City of Albuquerque

April 20, 1995

RE: REVISED DRAINAGE PLAN FOR 1623 SAN MATEO (J17-D21)
REVISION DATED 4/11/95.

EXISTING SITE PLAN AND
PROPOSED SITE DEVELOPMENT PLAN
1623 SAN MATEO BLVD. NE
LOT B (0.1044 ACRES)
DANIEL D. MURPHY ADDITION
ALBUQUERQUE, BERNALILLO COUNTY, NEW MEXICO

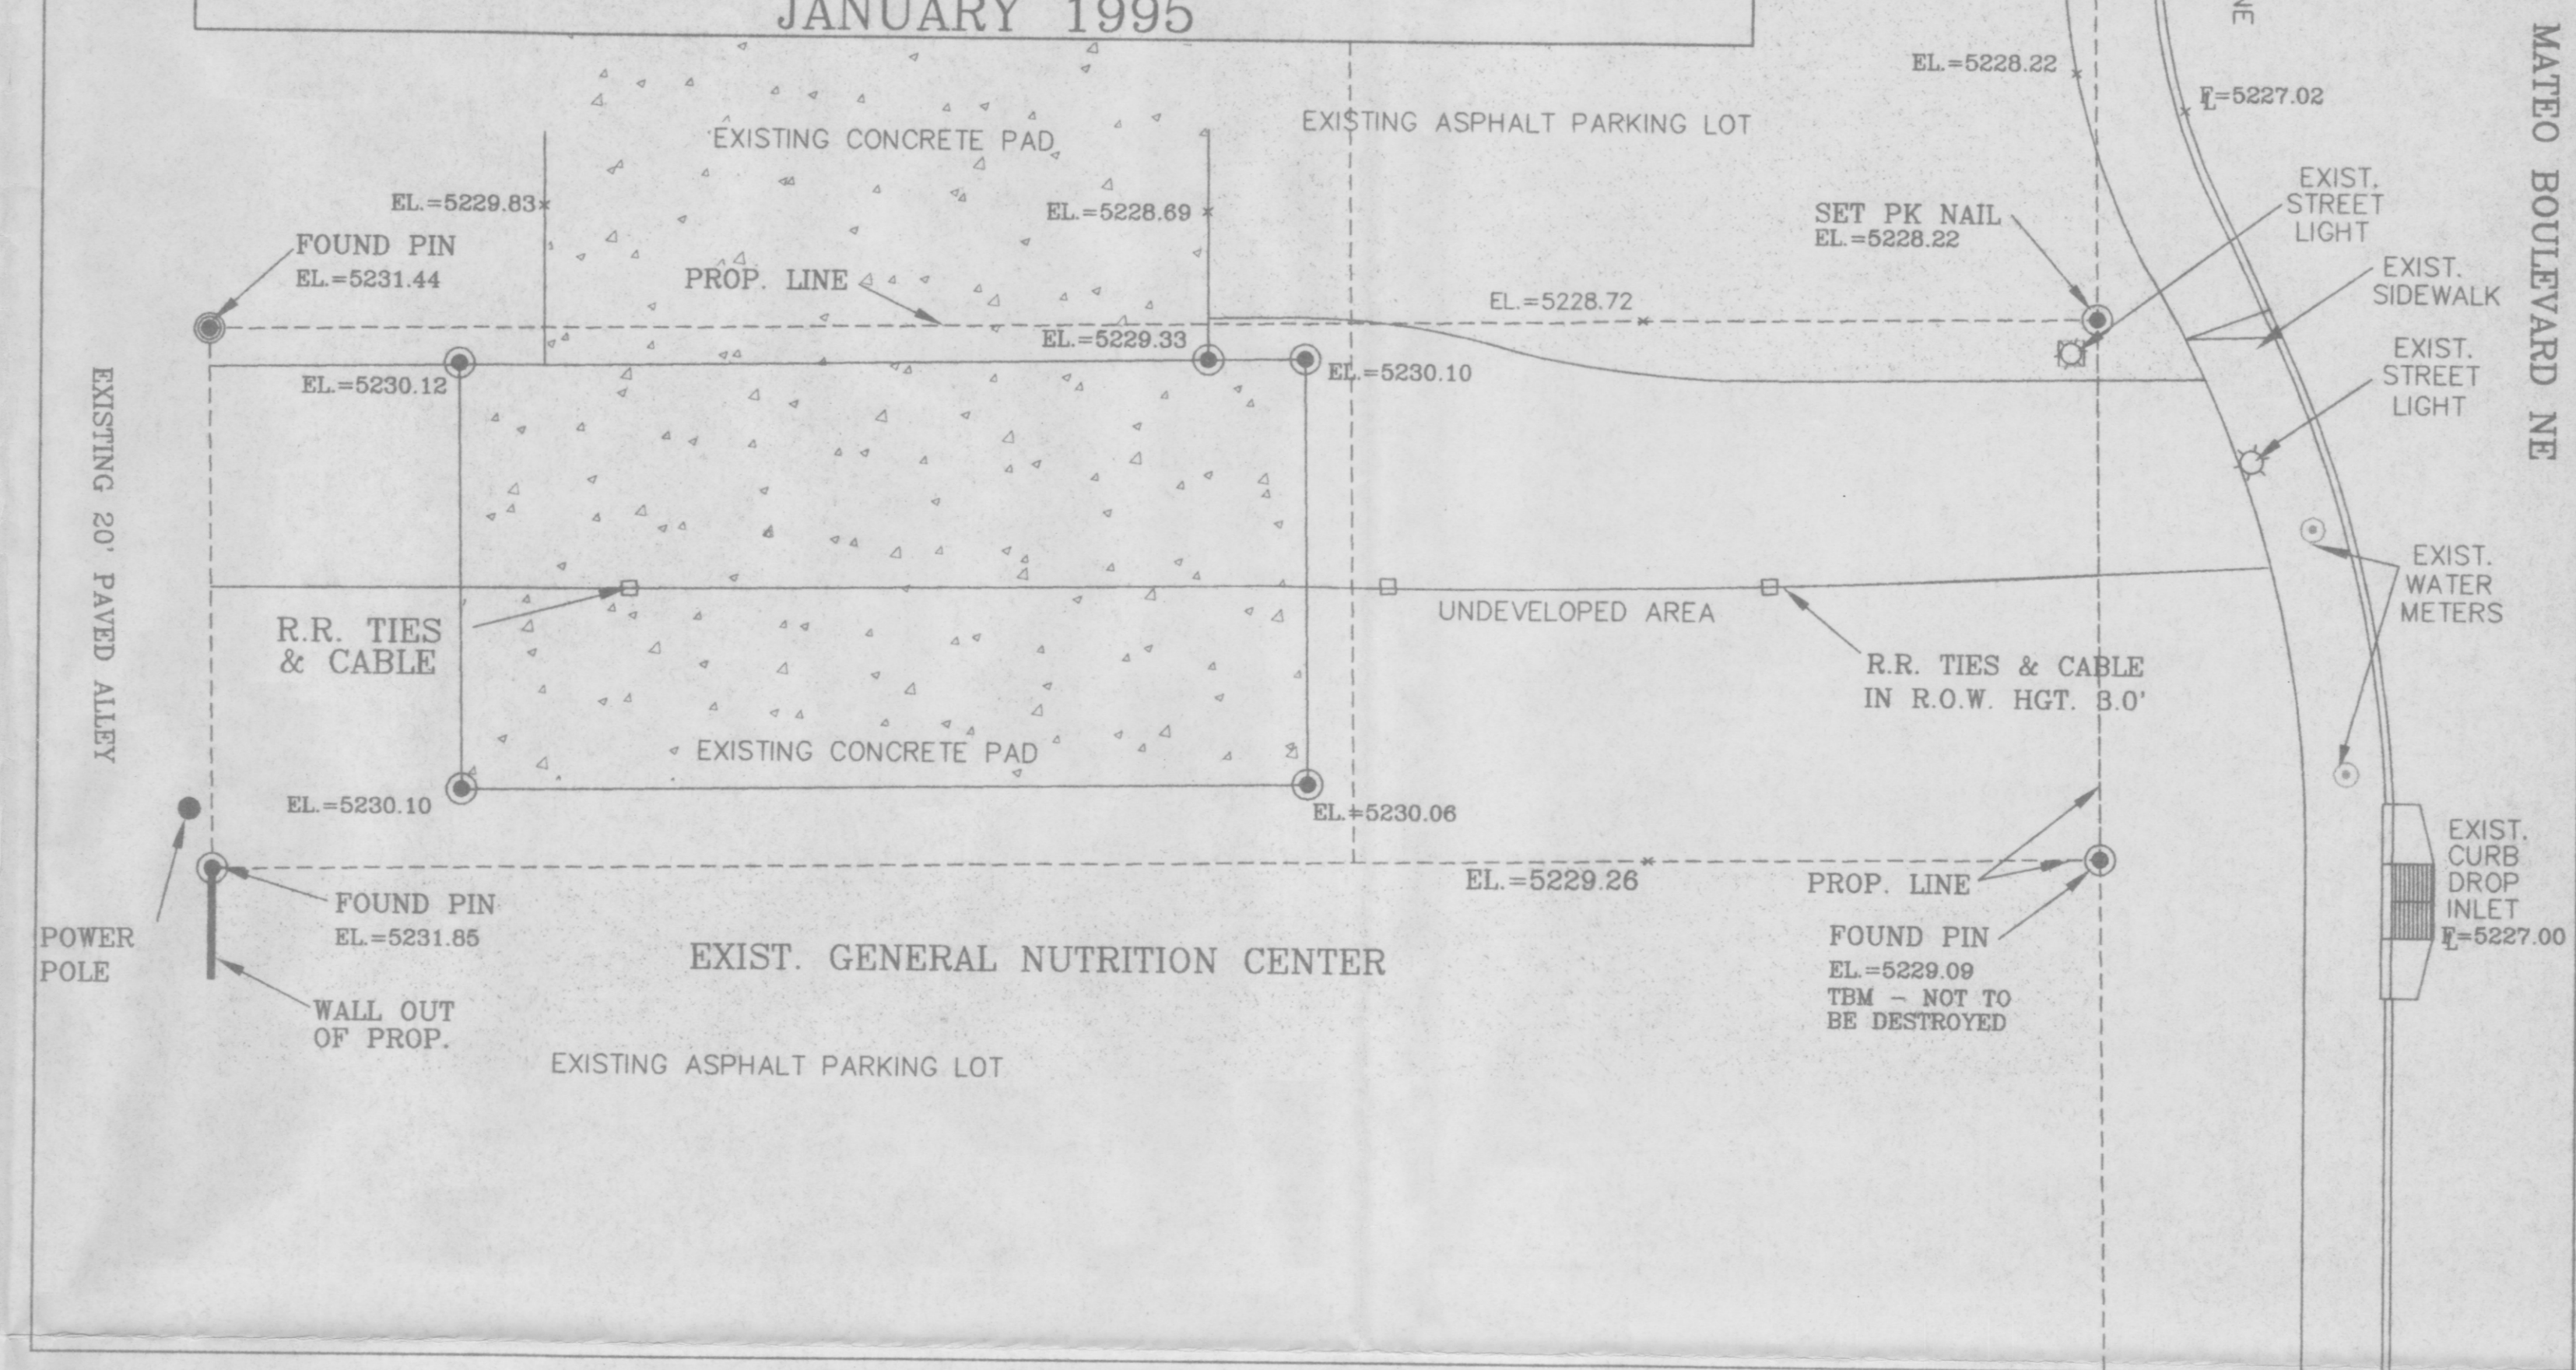
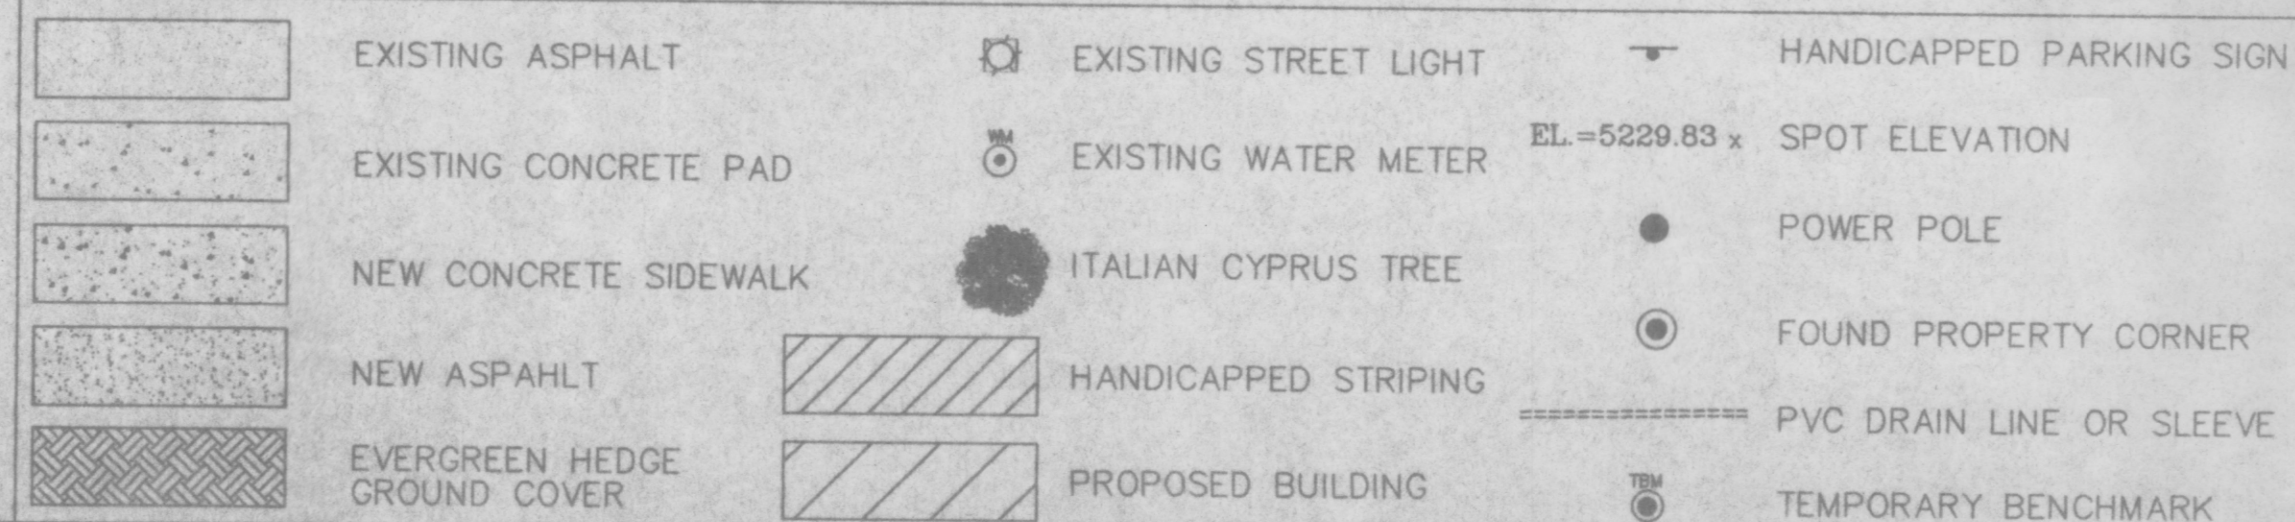
Based on the information provided on your April 18, 1995 resubmittal, the above referenced site is approved for Building Permit.

Please attach a copy of this approved plan to the construction sets prior to sign-off by Hydrology.

Also, prior to Certificate of Occupancy release, Engineer Certification per the D.P.M. checklist will be required.
